Application No: CM/16/20/PL
Site Address: Langford Horsemere Green Lane Climping BN17 5QZ
Description of works: Variation of condition 2 imposed under CM/64/19/PL to substitute House Type F floor plans & House Type F elevations.

Thank you for your internet representation made on 30th June 2020 which has been recorded as an objection with the comments as follows:

Project:
LANGFORD
HORSEMERE GREEN LANE
CLIMPING
Drawing Title:
HOUSE TYPE-F1
ELEVATIONS

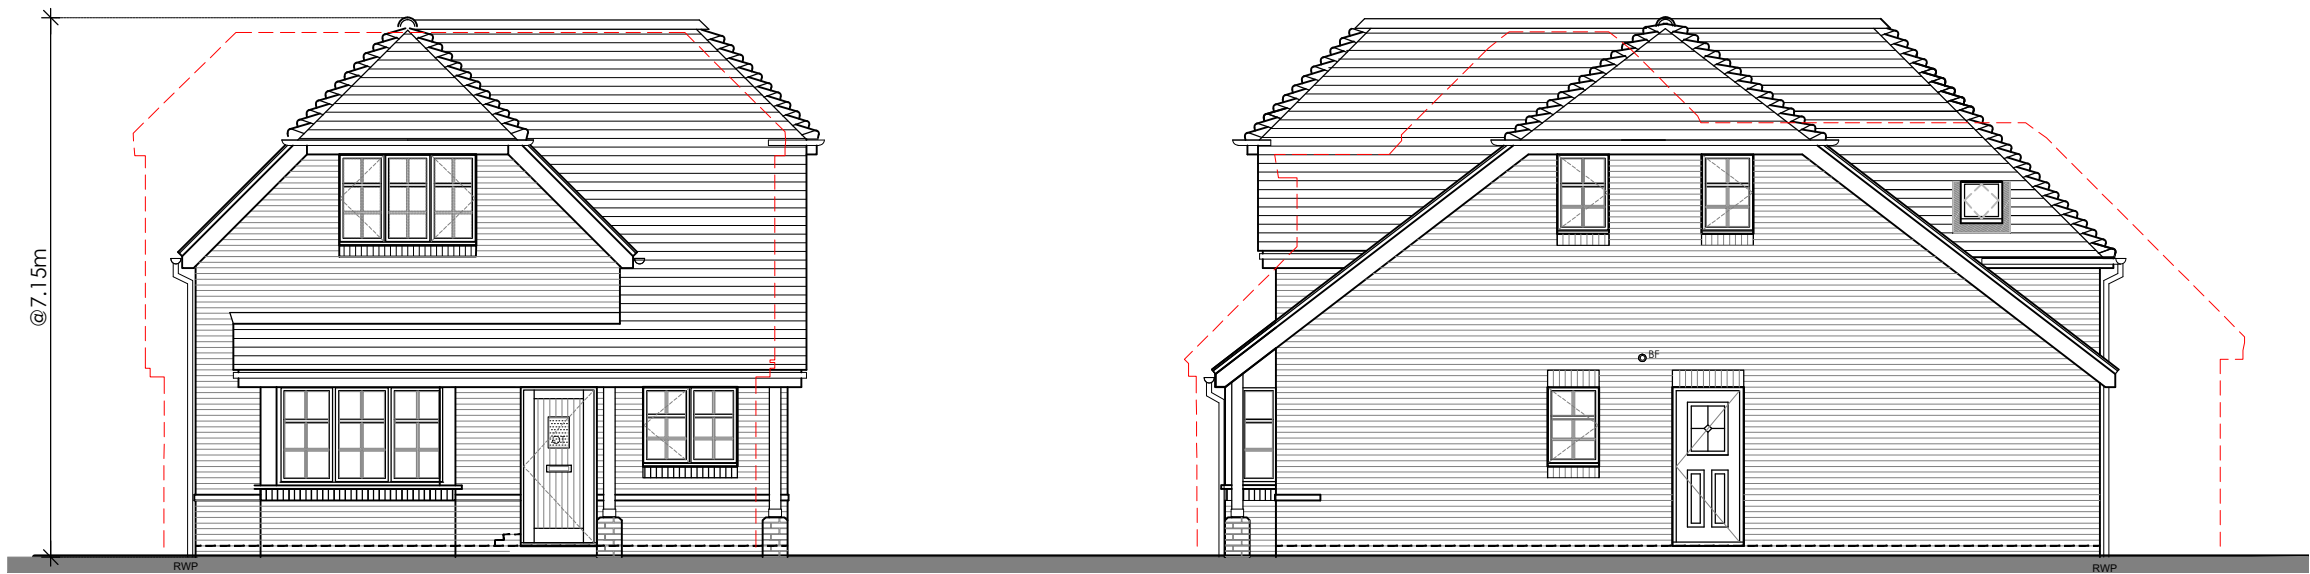
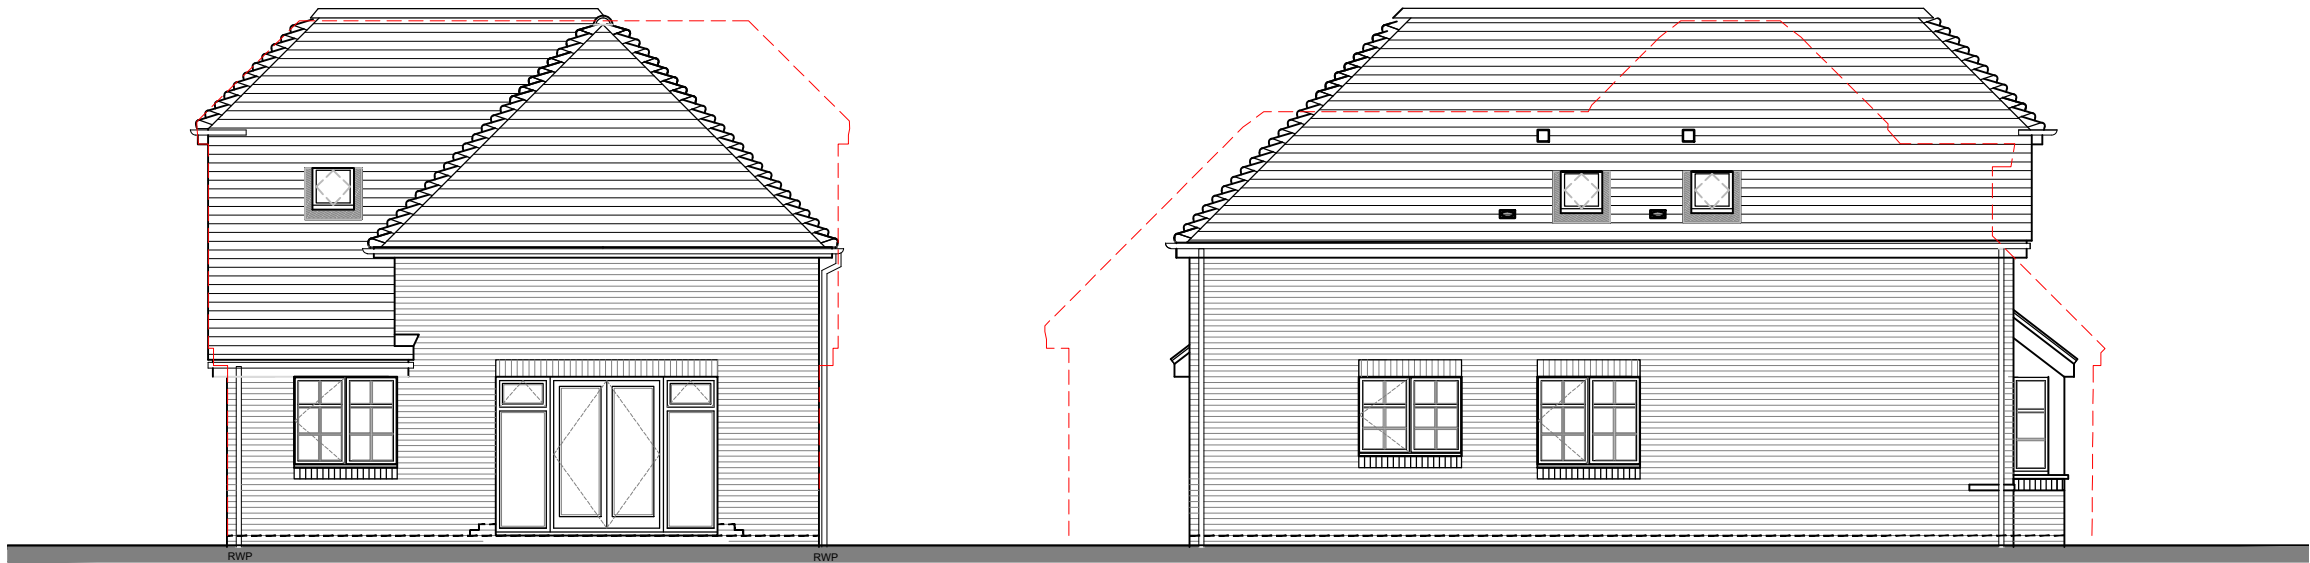
There are no height dimensions on the drawings. These need to be added so that the design can properly be assessed and be inspected once built.

The house appears to be 1m from my boundary wall. If this were an existing house applying for an extension the height of the roof would have to be 3m or lower 1m from the boundary and the height of the roof would need to be 4m or lower 2m from the boundary. Essentially they would not be allowed to build a two story building that close to my boundary.

The original plans were for a chalet bungalow with a flat roof presumably because they knew they had roof height planning issues. Indeed they have stated that the Council wanted them to reduce the height of their roof. The Council didn't ask them to build a house with a flat roof, this was their decision. To avoid the technical and maintenance issues associated with a flat roof they could have decided to build a bungalow with a pitched roof which would have been far more sensible.

Scaling off their drawing the house is clearly too high and would adversely affect my property especially as it is to the West of my garden where the sun sets.
